Kariong Sand and Soil Supplies Response to Submissions Plan second EIS October 2020

Figure 3.5. Location of waste storage areas during operational phase (residual waste marked by red squares).

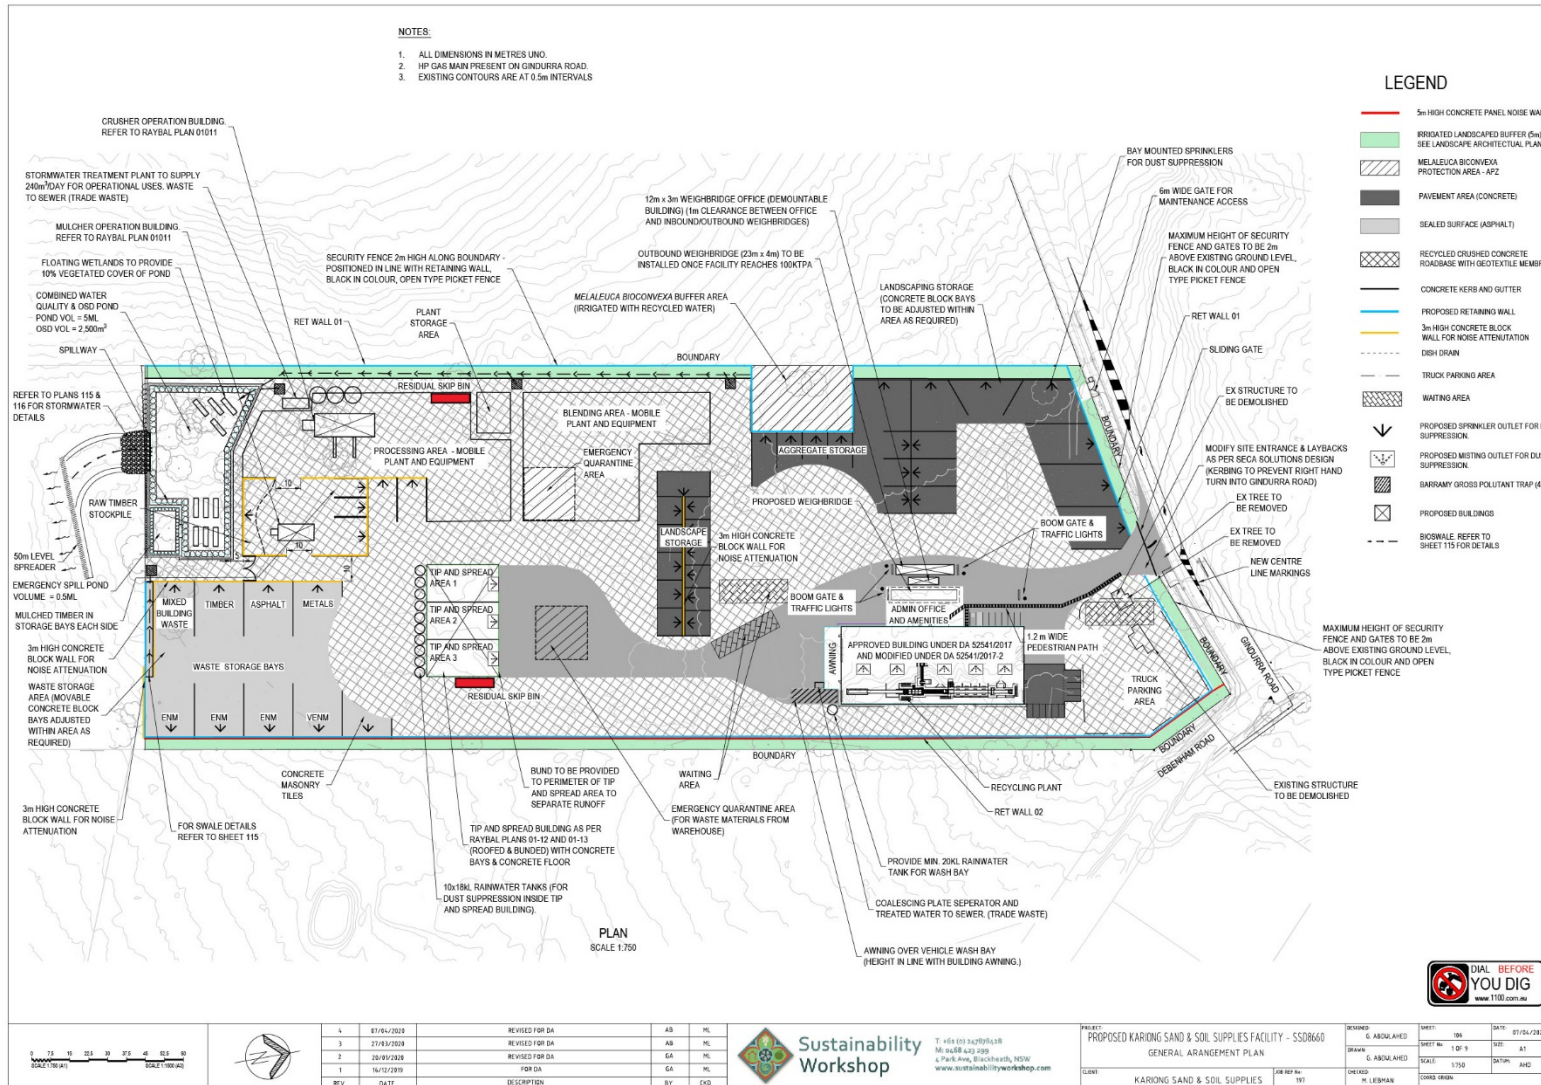
45	Other issues	DPIE	The Department notes Figure 3.5 of the WMP shows skip bin locations, but these locations are not shown on the civil plan. Please update the civil plan to ensure its consistency with the WMP.	The site layout plan shows fixed infrastructure, as is relevant to the development application. Skip bins are, by their nature, not fixed infrastructure. The likely location of residual waste skip bins has been included in the Waste Management Plan in response to a previous comment from DPIE. However, it should be noted that skip bin can be moved to suit the operational needs of the facility at any point in time.

SCALE	SHOWN	INT.	SHEET
DRAWN	A.G.		H101
DESIGNED	S.G.T.		
CHECKED	B.T.R.		
DATE	DECEMBER 2019		REV B
JOB NUMBER	20180015A

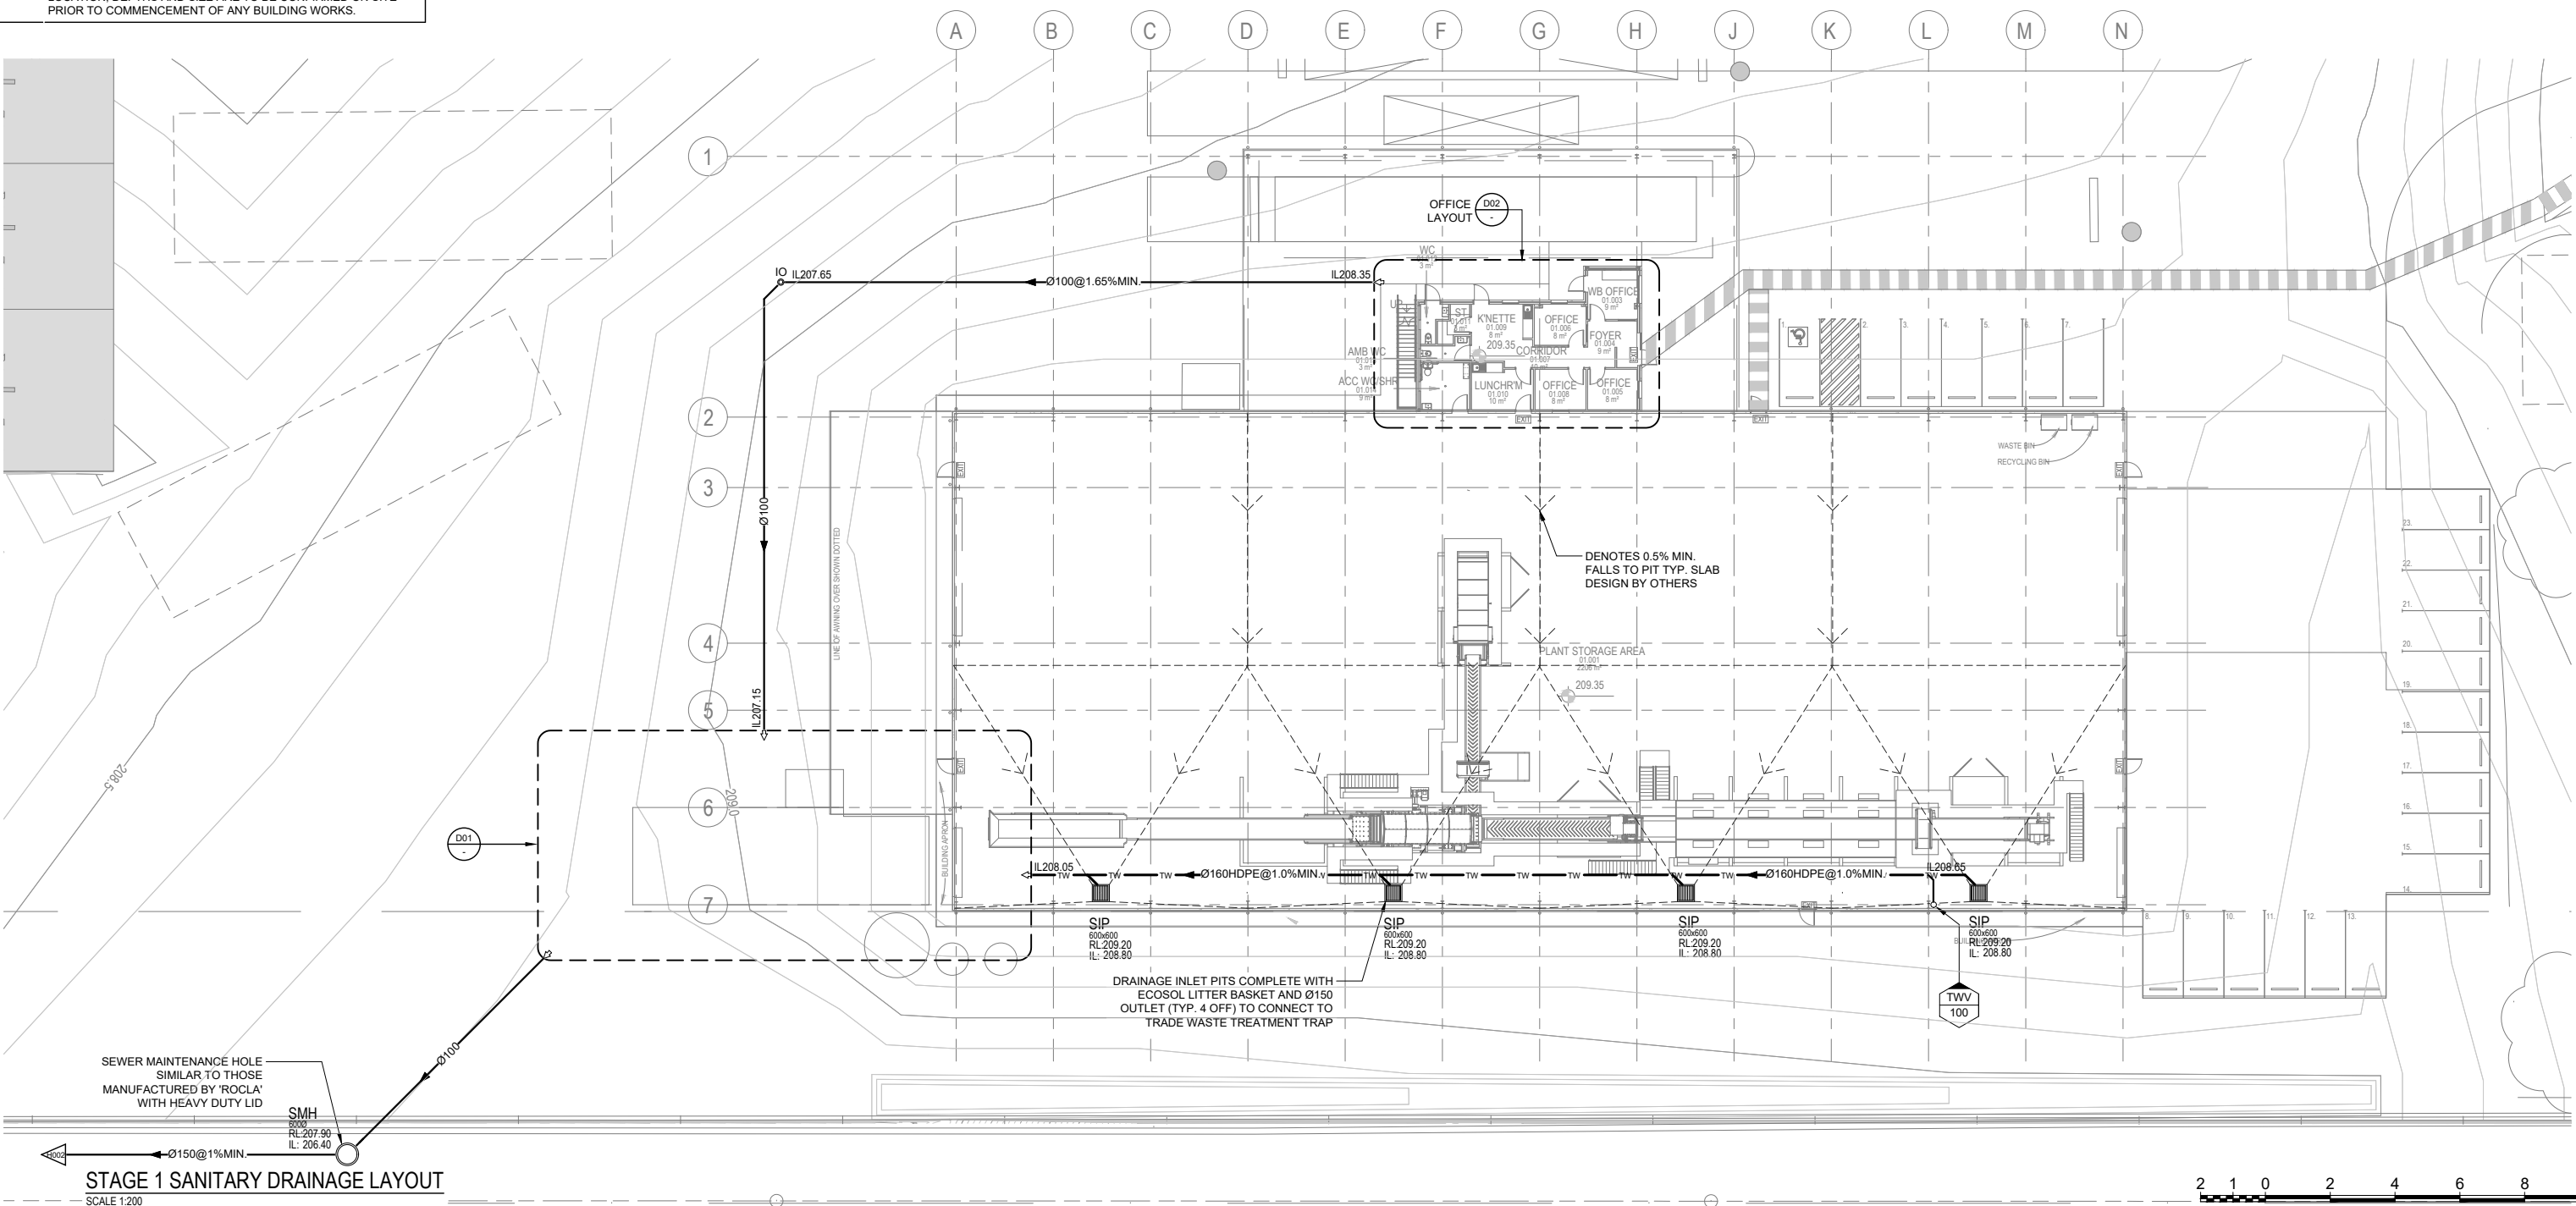
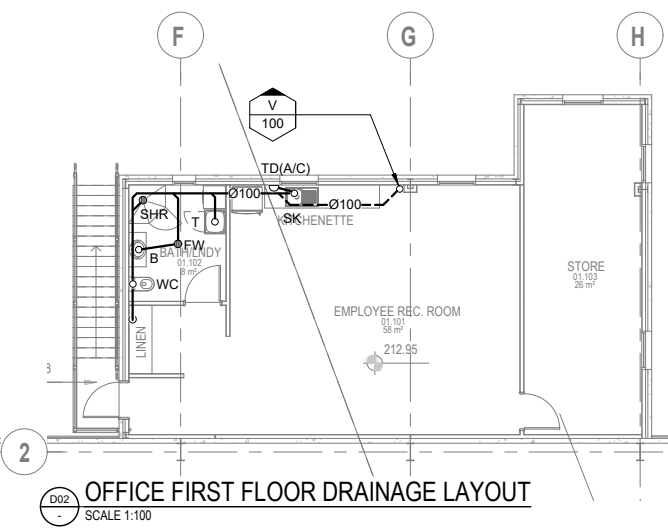
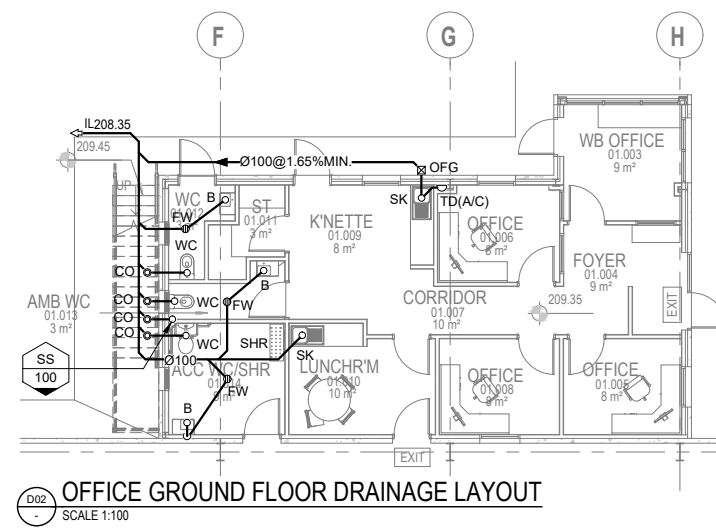
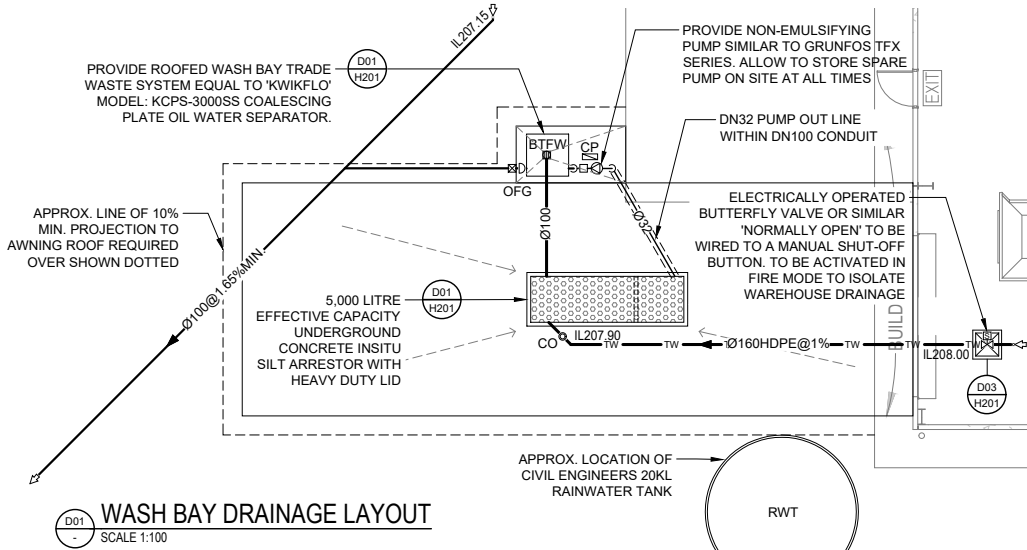
No.	Issue	Agency	Comment	How addressed
			Therefore, the EPA requires additional information (I.e. proof of concept) from the applicant in respect of the proposed Floating Treatment Wetland and its ability to prevent, control, abate or mitigate pollution caused by the construction and operation of the proposed waste facility.	
8	Water	NSW EPA	<p>Consistent with advice previously provided by the EPA, residual risks to water quality can be appropriately managed through conditions of consent. The EPA has updated the previously recommended conditions of consent to reflect the updated terminology in the June 2020 report.</p> <p>The following conditions of approval are recommended to manage residual soil and water quality risks:</p> <ol style="list-style-type: none"> 1. The southern portion of the site (approximately 4ha) will remain as an undeveloped, vegetated buffer during the life of the facility. 2. The fate and potential impacts of any leachate from inside the warehouse is considered and appropriately managed (such as an internal sump). 	<p>Noted.</p> <p>Noted. However, the water management system is not dependent on any further polishing or treatment of discharge water by the bushland.</p> <p>There are four drainage inlet pits location on the eastern side of the warehouse (see RGH Stage 1 Plan H101) that are fitted with electrically activated butterfly shut off-valves that will act as sumps. Butterfly valves are activated in the event spill or fire. Pits are connected to wash down bay oil/water separator if any wash water is generated within the warehouse. The oil/water separator will be connected to sewer (see RGH Stage 1 Plan H201 – Appendix 10).</p>
